Consultation Response from KC, Highways Development Management		
2021/91638 Land at Hart Street, Newsome, Huddersfield, HD4 6LS		
Reserved matters application pursuant to outline application no.2016/91479 (appeal no. APP/Z4718/W/17/3173711) for erection of 22 dwellings		
Date Responded:02-06-2021	Responding Officer: Mark Berry	Responding Ref: 6-8NE-12

This is a reserved matters application pursuant to outline application no. 2016/91479 (appeal no. APP/Z4718/W/17/3173711) for the erection of 22, two and three bedroomed dwellings at land at Hart Street, Newsome, Huddersfield.

BIN LORRY TRACKING

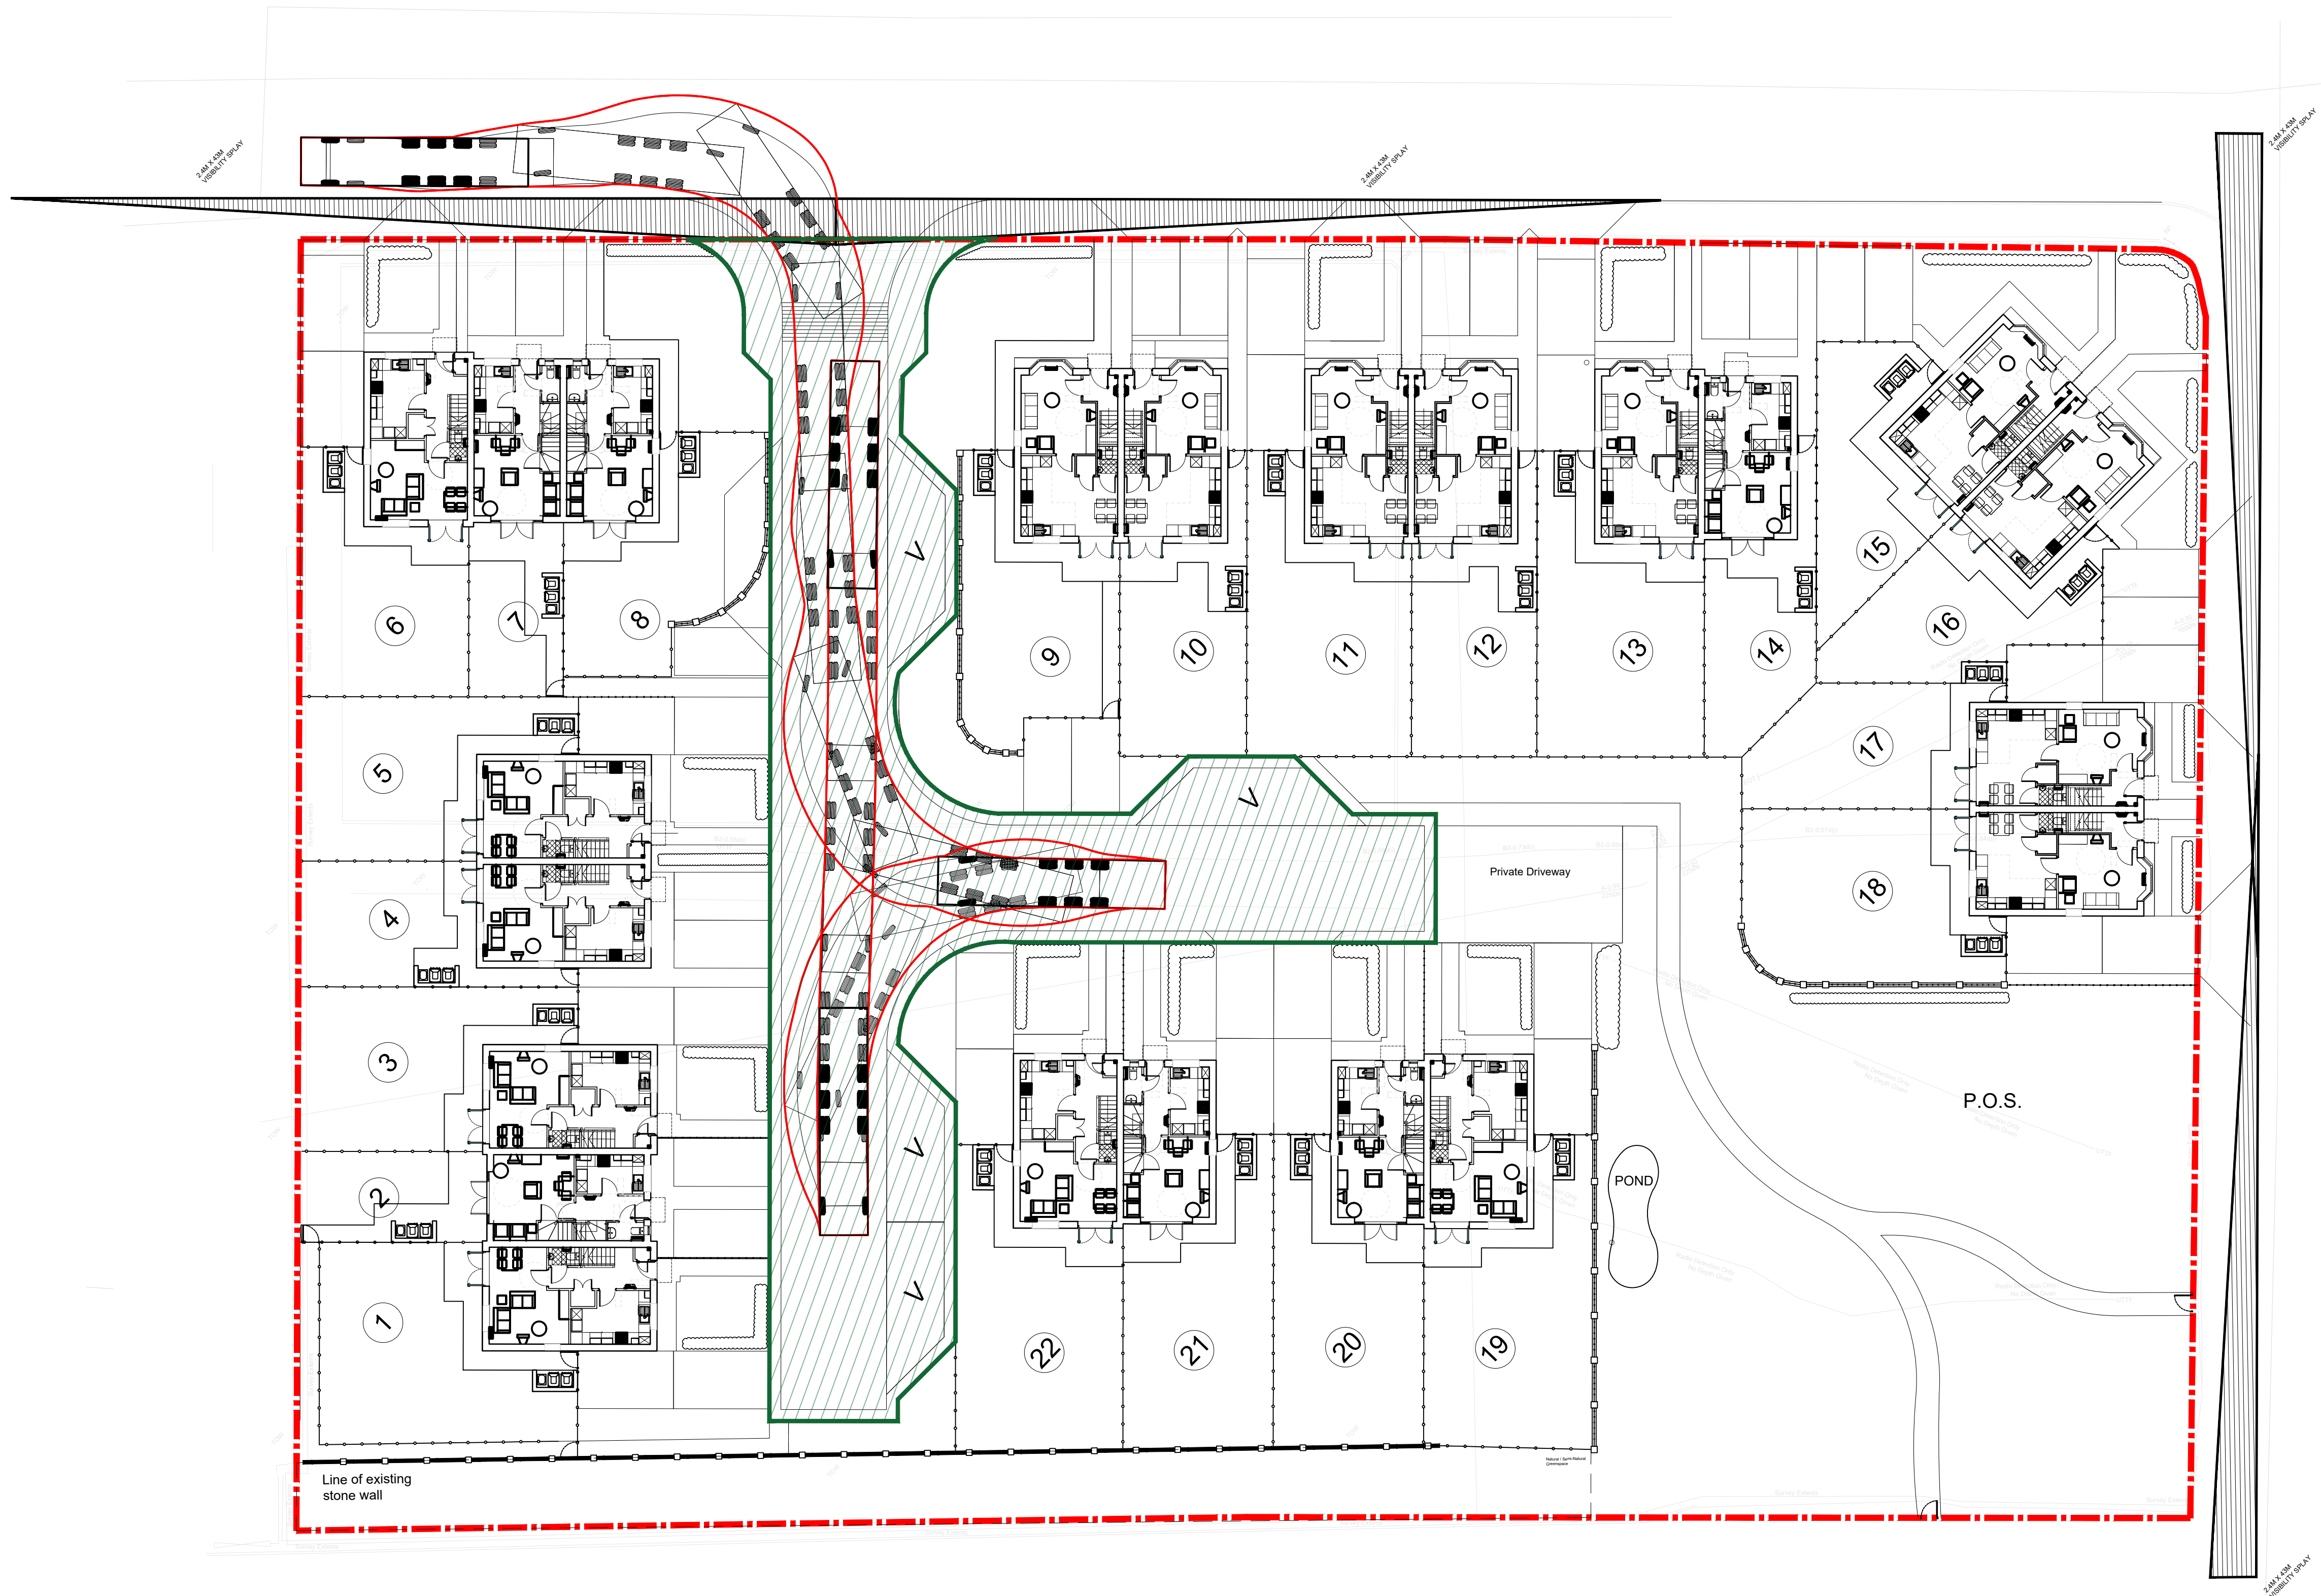
2, Swept paths should be provided to demonstrate that an 11.85 m refuse vehicle can enter and exit the site from Hart Street and turn within the site. All schemes must incorporate reasonable tolerances and safety margins. A good starting point is to allow 0.5m clearance to kerbing or vertical obstructions on each side of the swept path. Designs should therefore, where possible, aim to cater for vehicles larger than the above minimum standards.

8, Visitor parking should be provided at the rate of 1 space per 4 dwellings with access via the internal road. If visitor parking is to be on-street, swept paths should demonstrate that access and turning for the refuse vehicle is not obstructed.

PLANNING
DRAWING

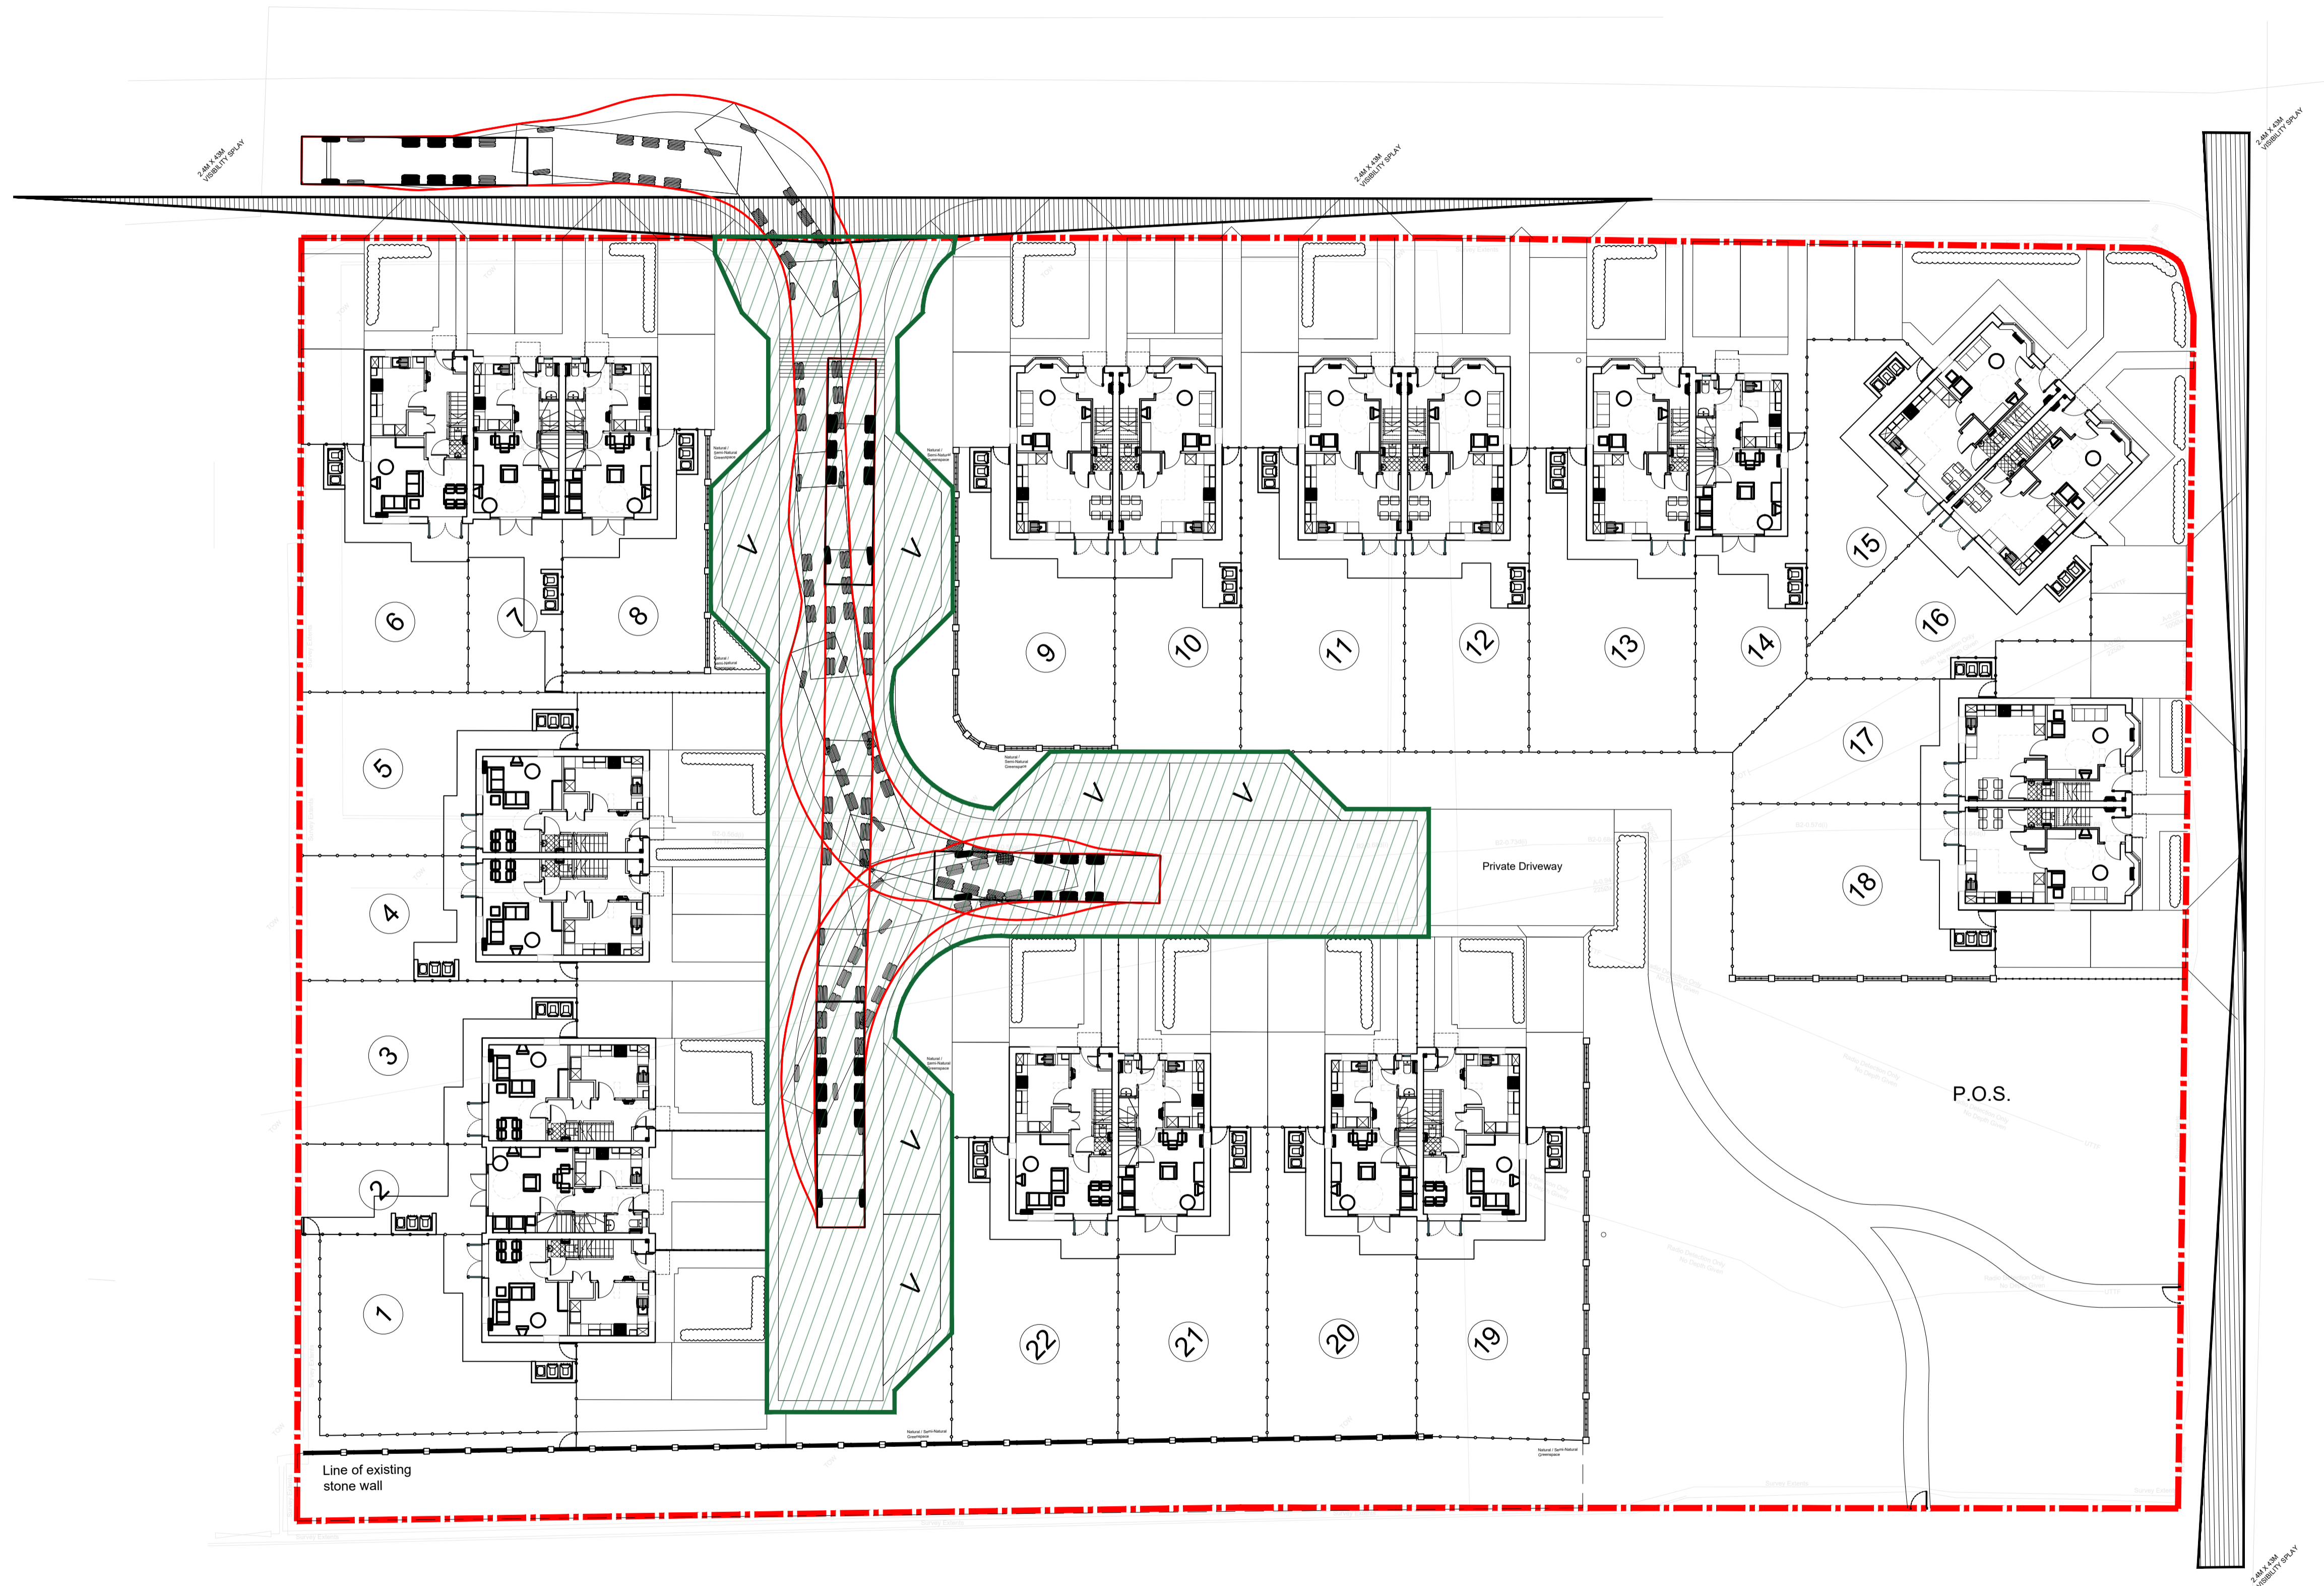
1, Direct frontage access onto Newsome Road should be avoided. Newsome Road is heavily trafficked, and this is not recommended.

4, Plot numbers 2, 13 to 15, 19 to 21 have insufficient off-street parking. Each plot should have 2 off-street parking spaces.

6, It's not clear from the proposals which areas of the internal access road are intended for adoption. Parking spaces cannot be included within the adoptable area and all sections of any shared surface carriageway should have a 600mm hard margin to all sections.

9, The parking spaces to plot 7 are located on the junction radii and are too close to the junction With Hart Street to be considered save.
